RE: 161 Marginal Way - Maine Eye

From: Barbara Barhydt [mailto:bab@portlandmaine.gov]
Sent: Friday, May 13, 2016 1:24 PM
To: Paul Ostrowski
Subject: 161 Marginal Way - Maine Eye

I have looked at the administrative authorization that was submitted and I have some questions:

ENLARGED PLAN  
ROTATED 180°

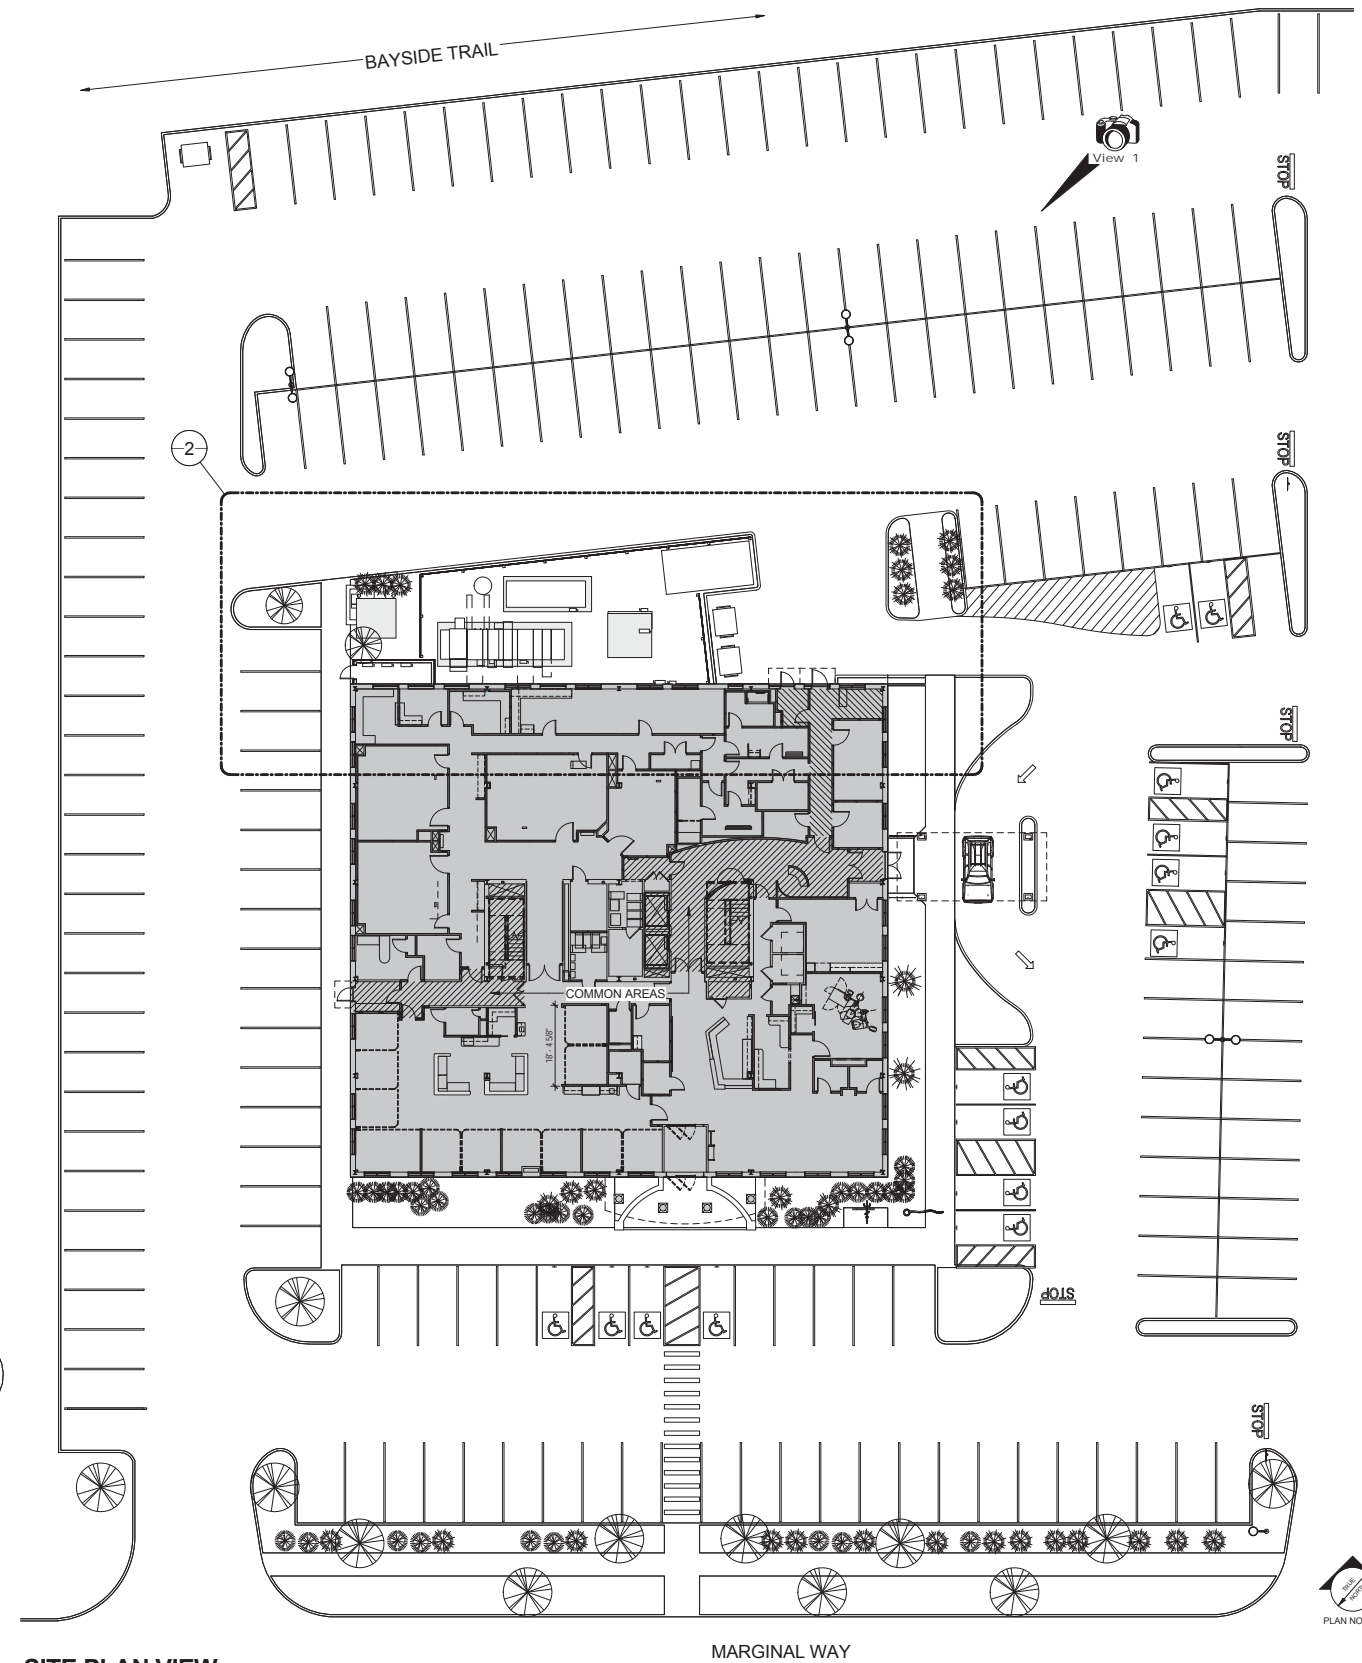
- Is the side entrance for Maine Eye only? Will the front building entrance remain a functional entrance.
- Most of the plans show the dumpster location facing out toward the trail, but the architectural has it tucked behind a shed. What is the alignment and what is being used to screen the dumpsters?
- Is a shed being proposed and what is the size?
- What is the footprint of the equipment in the rear?
- How will the parking function with the drop off area and is this proposed as a one-way circulation?
- We encourage a connection to the trail and is there a detail for the gate? Will the gate be open for use at all times?

**SITE PLAN**  
OF: **MAINE EYE-RETINA AND SURGERY CENTER**  
161 MARGINAL WAY  
PORTLAND, MAINE 04101  
FOR: **MAINE EYE CENTER**  
15 LOWELL STREET  
PORTLAND, ME 04102

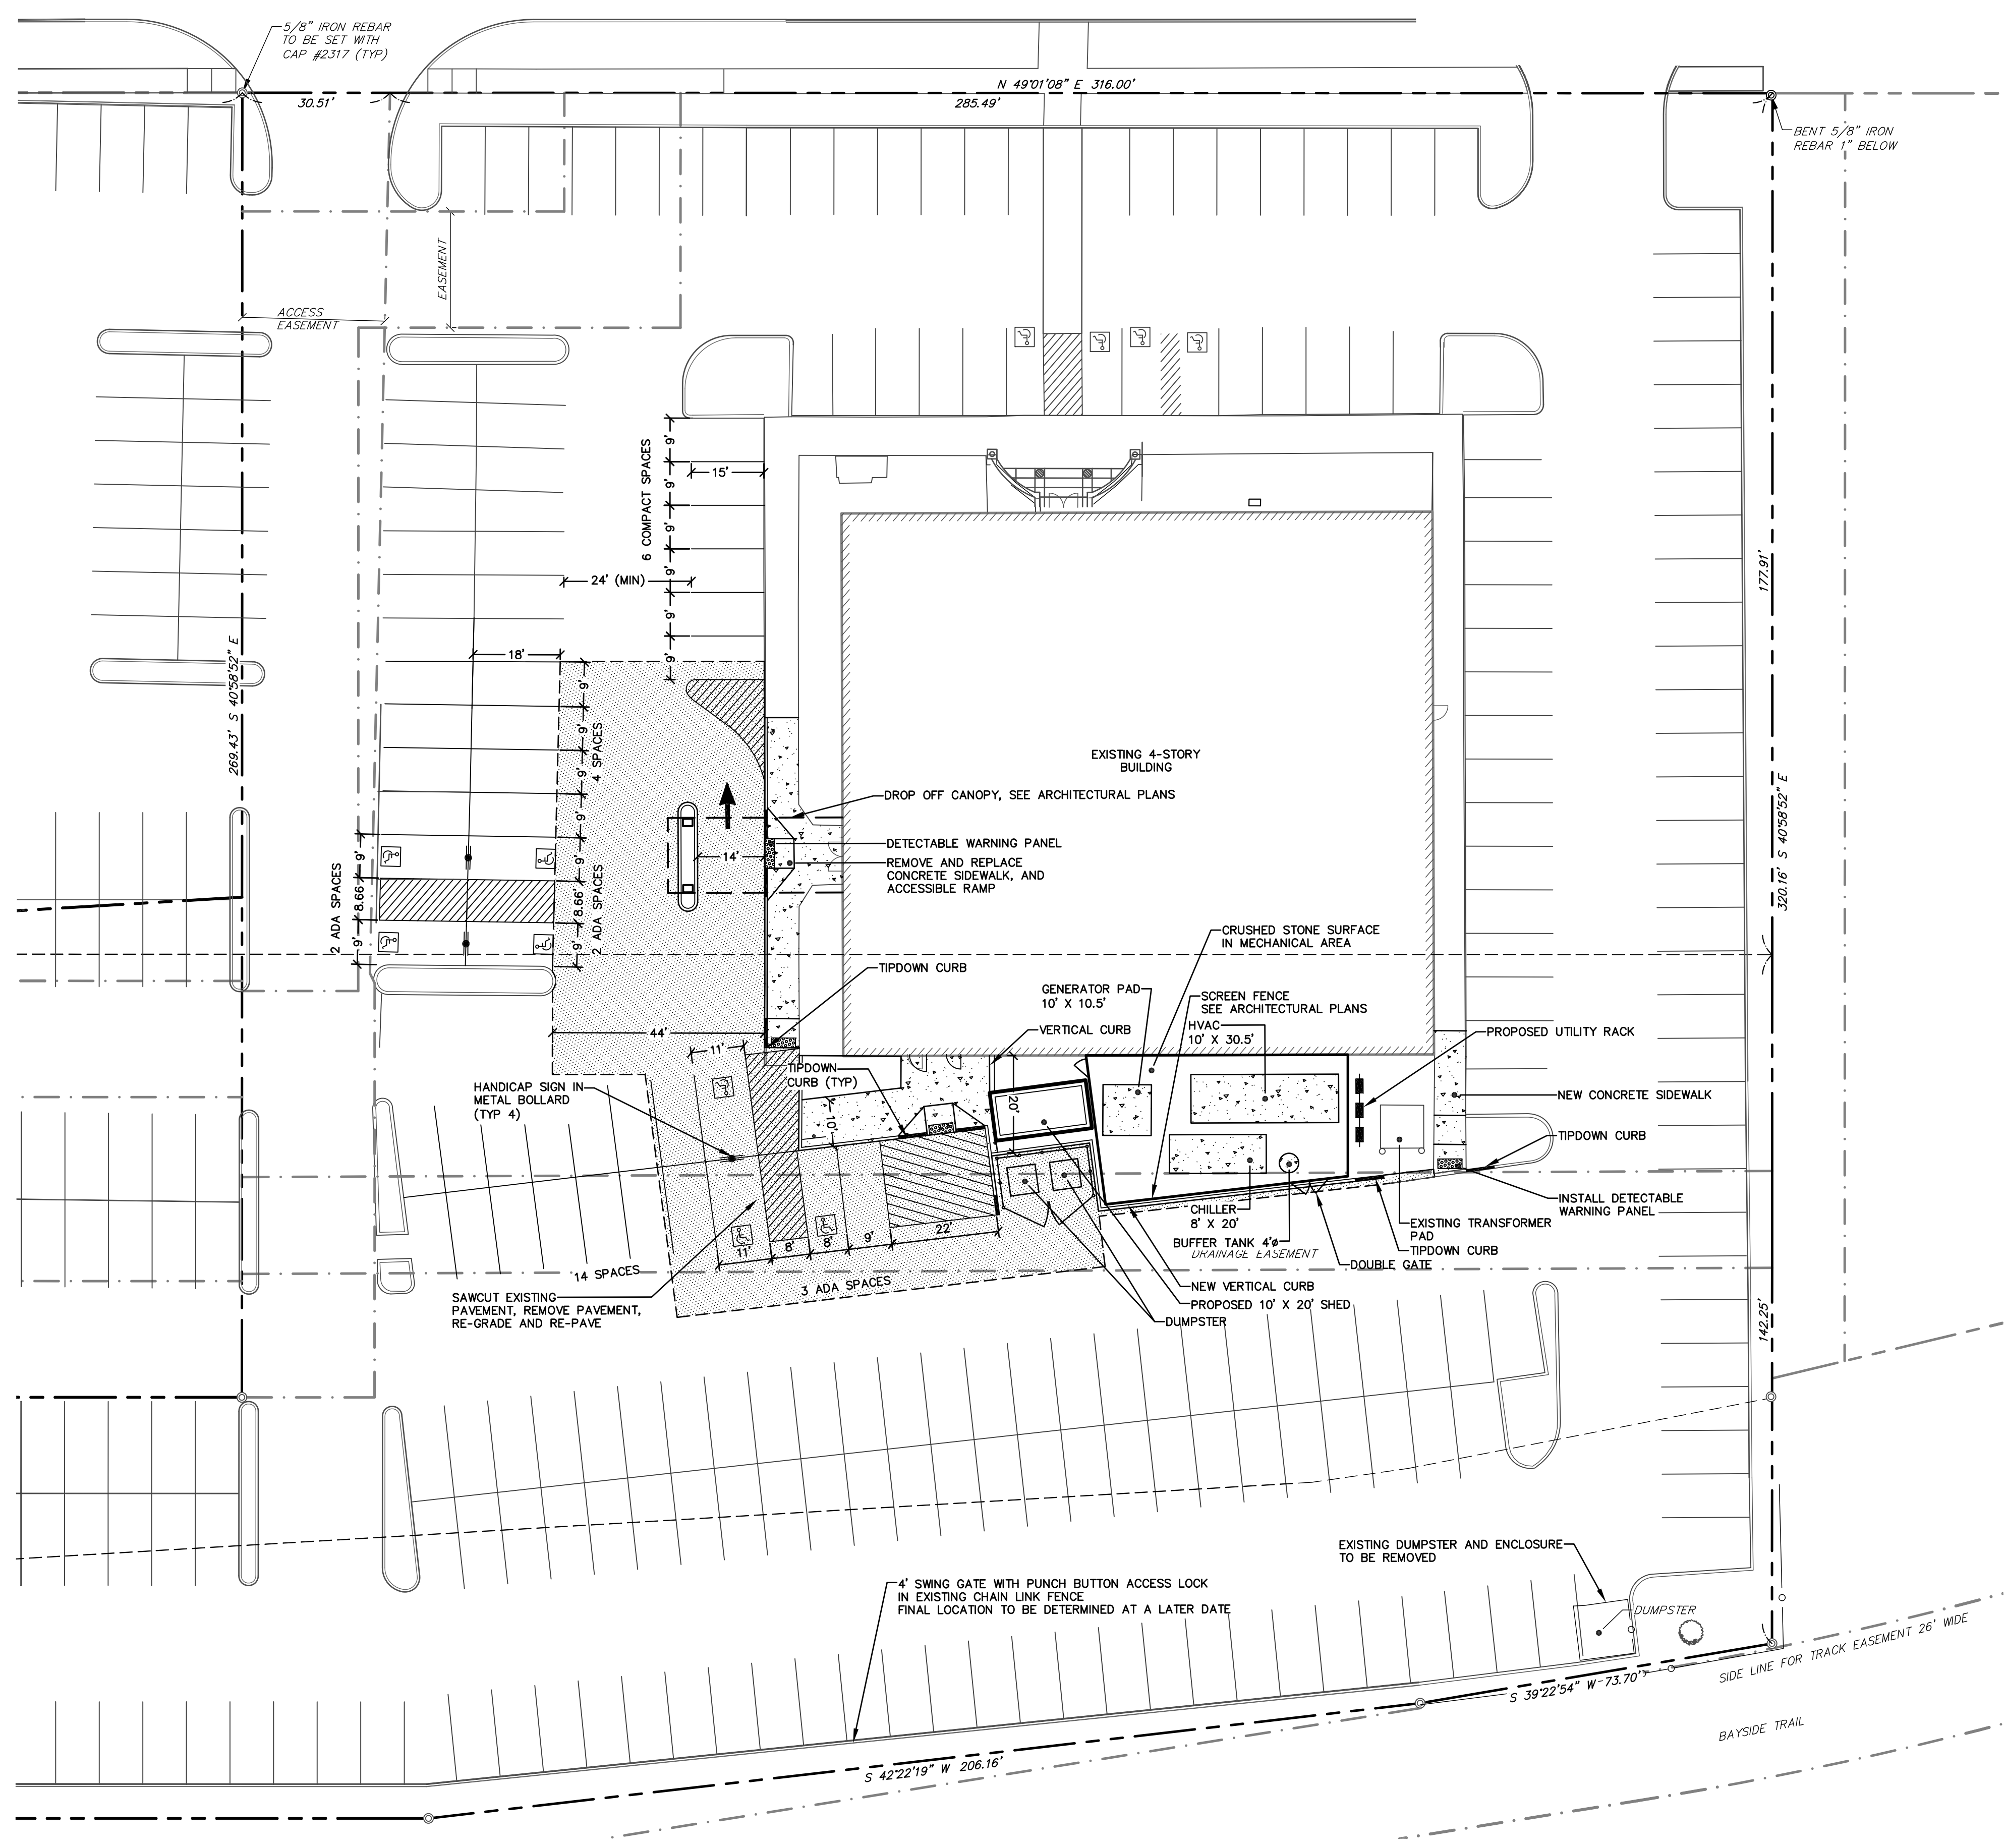
Let me know if the space can return to compact and please send me a revised plan. I will try to talk with Tom today, but I think I will be able to sign off quickly.

The 6 spaces along the side curblineline of the building are depicted as compact spaces which provides for a minimum 24' drive aisle.

Comment response letter attached along with updated site plan and grading plan. The site plan has been updated to add dimensions of the concrete pads as well as a traffic direction arrow at the drop off loop. Grading plan has added note regarding removal of existing dumpster.
